Application Ref:		3/2026/0413		 Ribble Valley Borough Council www.ribblevalley.gov.uk
Date Inspected:	N/A	Site Notice:	N/A	
Officer:	AR			
DELEGATED ITEM FILE REPORT:				PERMISSION REQUIRED

Development Description:	Prior approval for proposed single storey rear extension under Part 1 Class A of the GDPO.
Site Address/Location:	7 Knowsley Road West, Wilpshire, BB1 9PW

Proposed Site Plan
Scale (1 : 5 0 0)

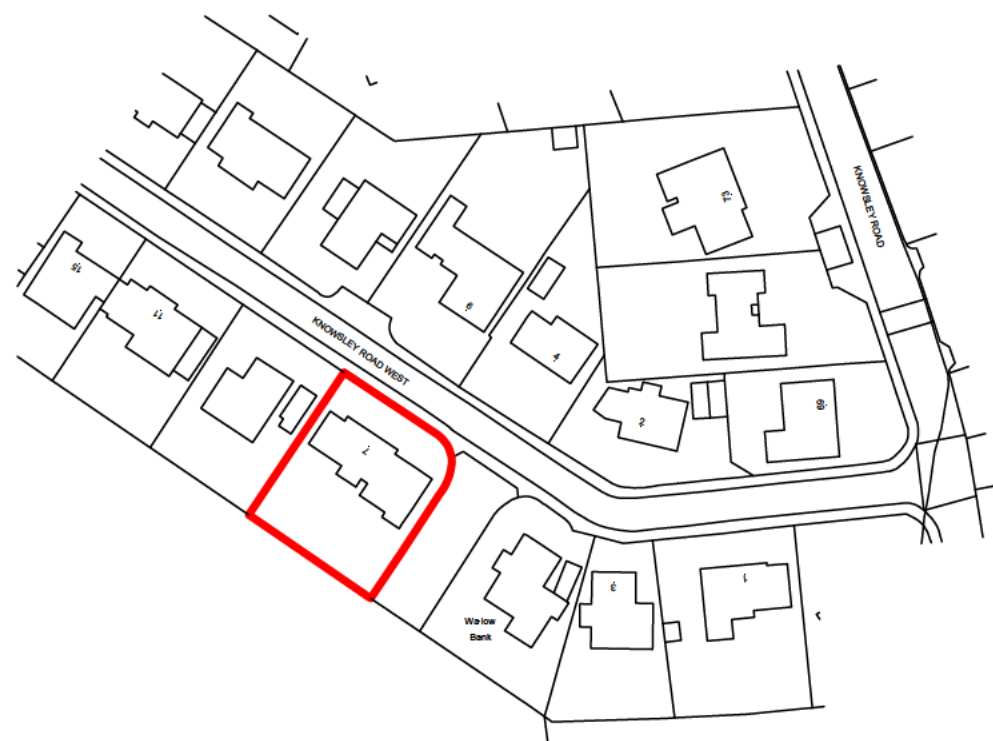
The enlarged part of the dwellinghouse would not be within 2 metres of the boundary of the curtilage or the dwellinghouse.

The proposed extension would be situated 2.3m from the common boundary with No.5 Knowsley Road West, projecting 7.2m alongside it. However, the dwellinghouse at No.5 Knowsley Road West would be situated approximately 16m south-east of the proposed extension. Therefore, in this respect the proposed scheme as submitted would be unlikely to lead to any significant degree of overshadowing or loss of light to No.5 Knowsley Road West.

Proposed Ground Floor Plan
Scale (1:50)

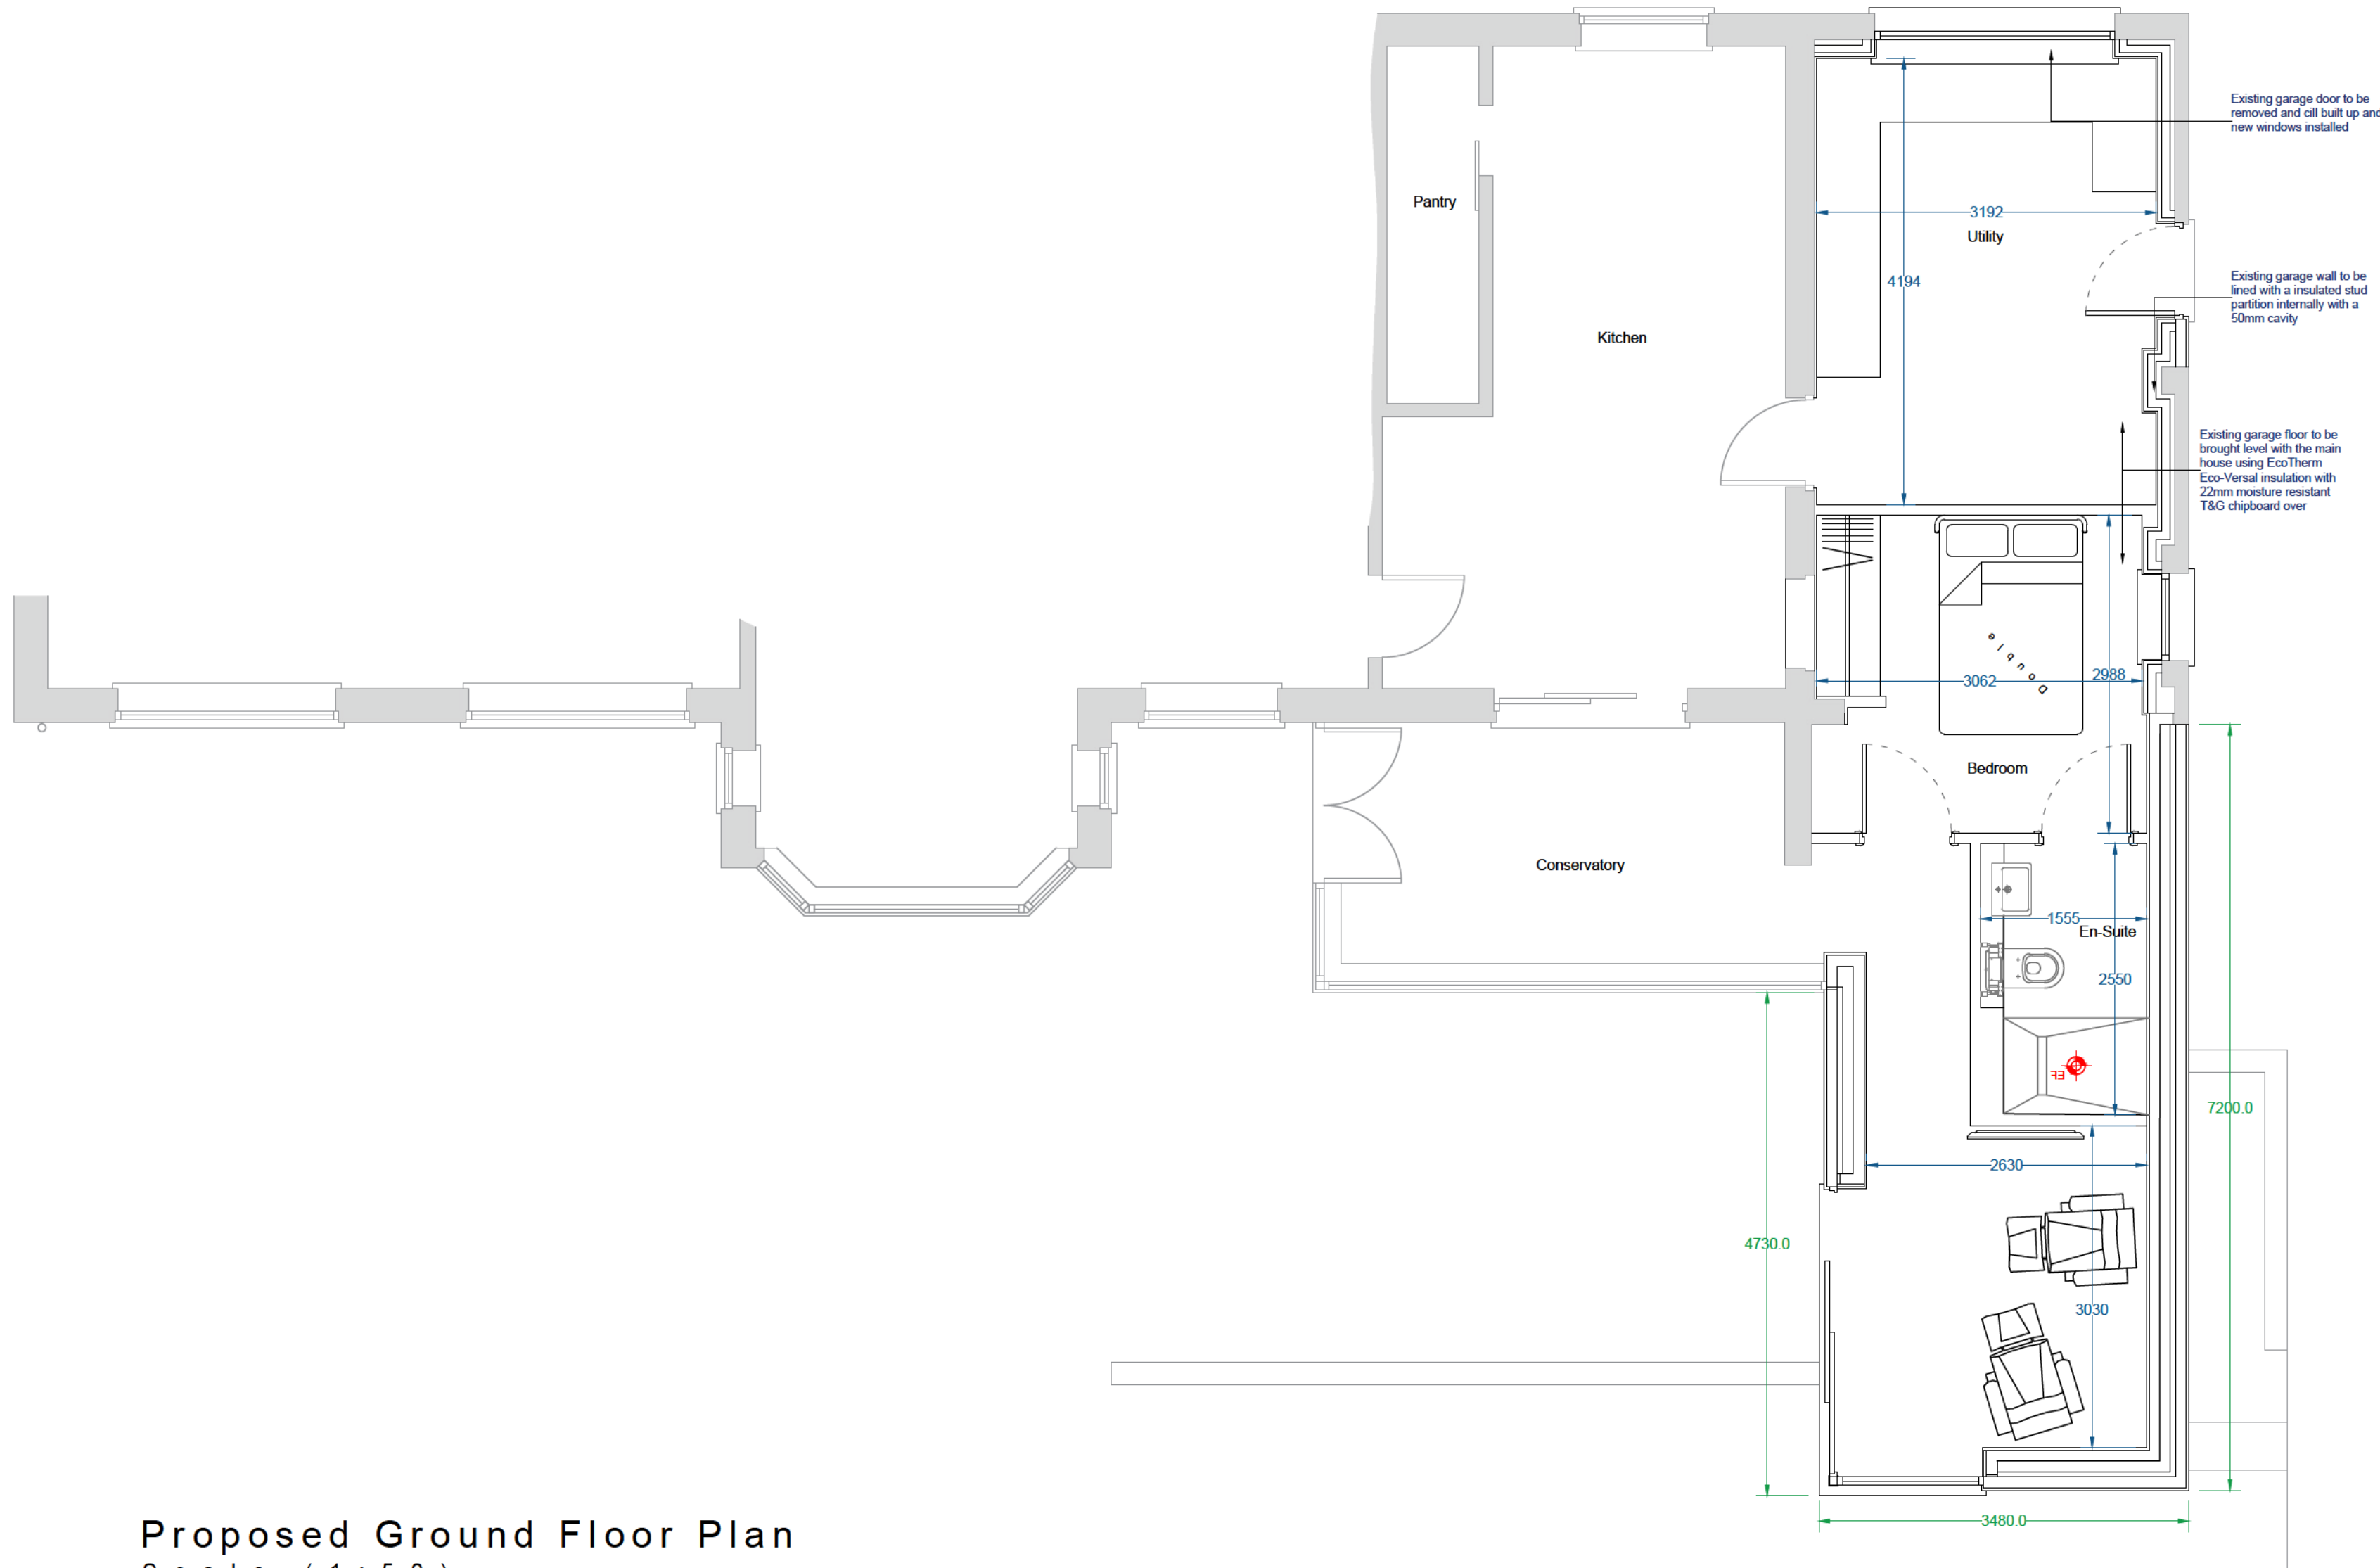
The proposed extension would be a single-storey structure adjoined to a detached dwellinghouse and would extend beyond the rear wall of the original dwellinghouse by 7.2 metres and would have a maximum height of 3.85m.

The dwellinghouse is not situated on Article 2(3) land nor on land of special scientific interest. The application property is a detached dwellinghouse, and the proposed extension would extend beyond the rear wall of the application property by 7.2m and would not exceed 4m in height. The proposal therefore, complies with the above.

The enlarged part of the dwellinghouse would extend beyond a wall forming a side elevation of the original dwellinghouse; however, it would not exceed 4 metres in height, have more than a single storey or have a width greater than half the width of the original dwellinghouse.

The proposed enlargement would adjoin the existing rear and side extensions granted consent under application references: 3/2001/0247, 3/2000/0193 and 3/1986/0648. The total enlargement, being the proposed extension together with the existing rear and two side extensions, would exceed the limits set out in sub-paragraphs (f), (g) insofar that the total enlargement would have a single storey and would exceed 4 metres in height.

As such, the proposal fails to comply with criterion (ja) and therefore does not fall to be permitted development in the first instance.
